## DECISION DELEGATED TO HEAD OF PLANNING

Application No:	H16-0588-25	Applicant:	Rollins Group
Proposal:	Proposed construction of staff car park to accommodate shift change parking, together with associated drainage, lighting, fencing and external works		
Location:	Pilgrims Europe Fulney Lane Spalding		
Terminal Date:	18th September 2025

Shift Change Car Park

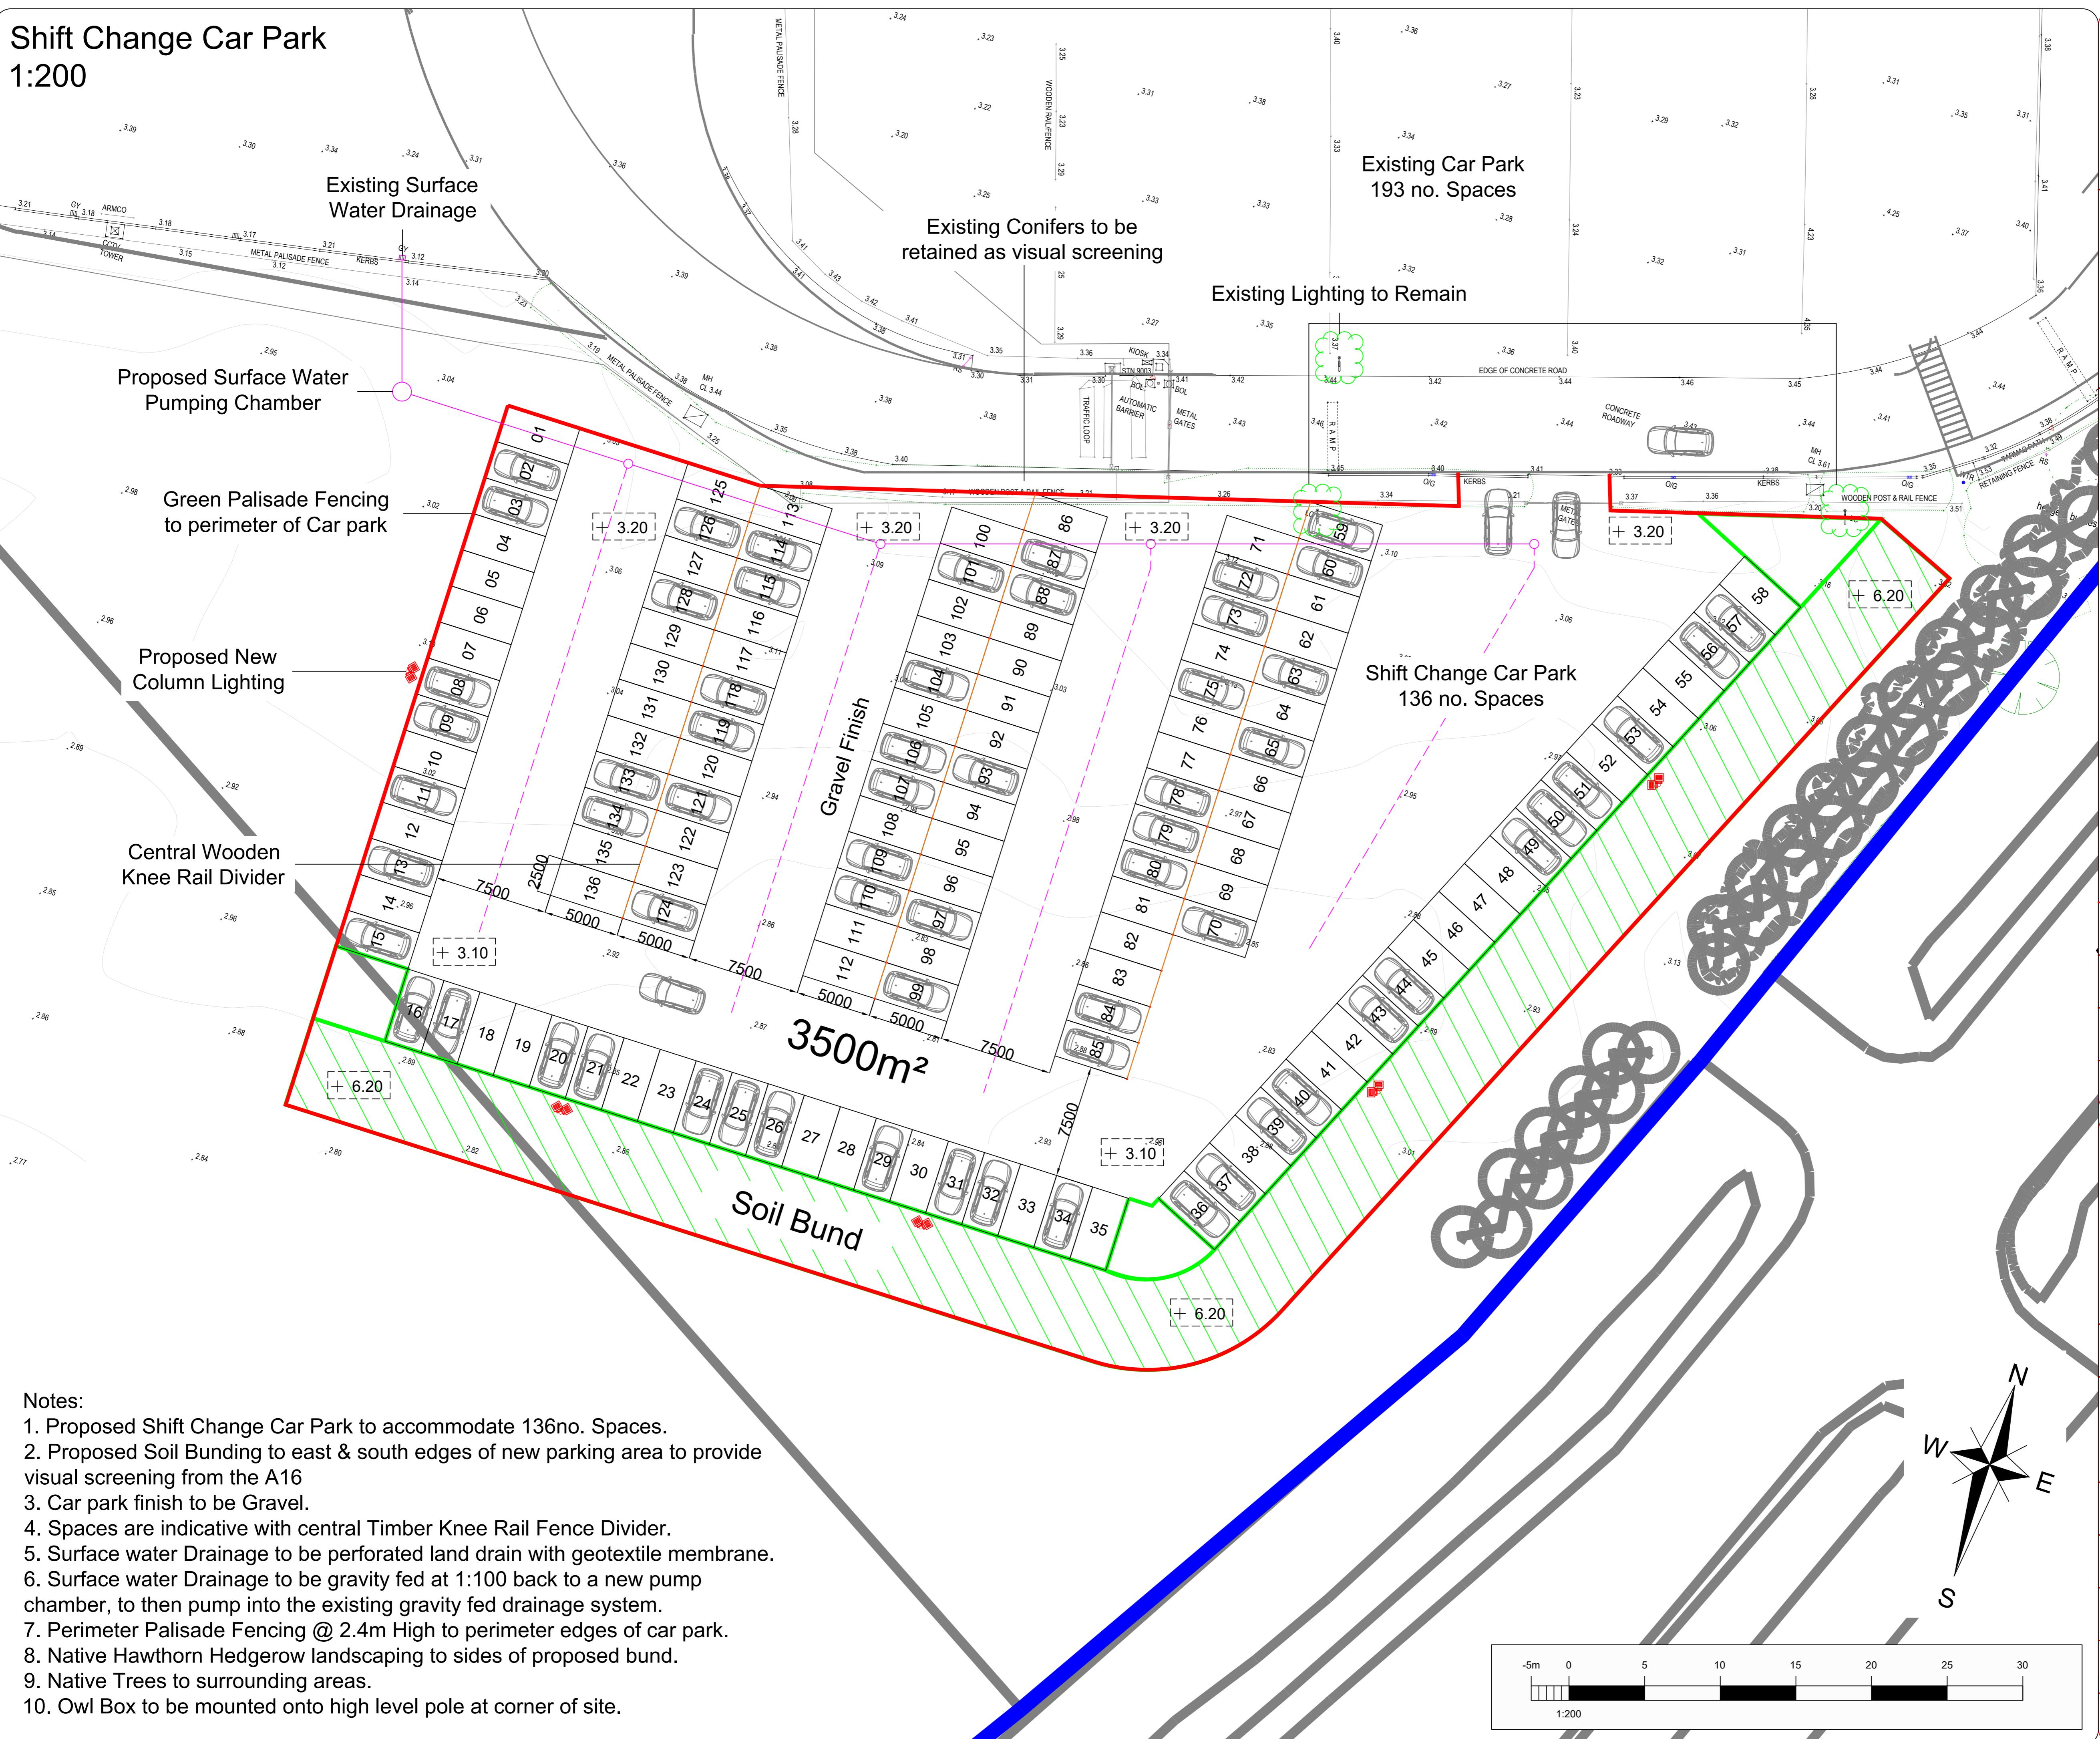
We understand that the applicant proposes to discharge surface water from the new car park into an existing surface water drainage system, as shown in drawing 'Proposed Block Plan' 0258/SC-02 (Rollins Group, 06/06/2025). We cannot see that a discharge rate has been provided for the impermeable area of the new car park entering this existing system. The Board recommend that any discharge is in line with the National standards for sustainable drainage systems (SuDS) published in June 2025. Further to the National Standards for SuDS, the Board's policy is to restrict discharges to 2/l/s/ha or annual average flood flow rate (QBar or QMed), whichever is higher.

With regards to the existing surface water drainage system, the Board has no knowledge of this privately maintained system, whether there is a connection to the wider drainage network nor at what discharge rate. With no evidence of a viable route for surface water to discharge to, we are concerned that the increase in contributing impermeable area discharging into the existing system may increase flood risk in the surrounding area, due to the lack of a feasible connection from the site to the Board's arterial system. In light of this, the Board object to this planning proposal and request further information is submitted which provides further details on this existing system, how it connects to the wider drainage network and at what discharge rate.

Given the limited information made present regarding the existing surface water drainage strategy, and the IDB objection it is considered that a condition requiring a more detailed drainage strategy is justified, and will be duly attached.
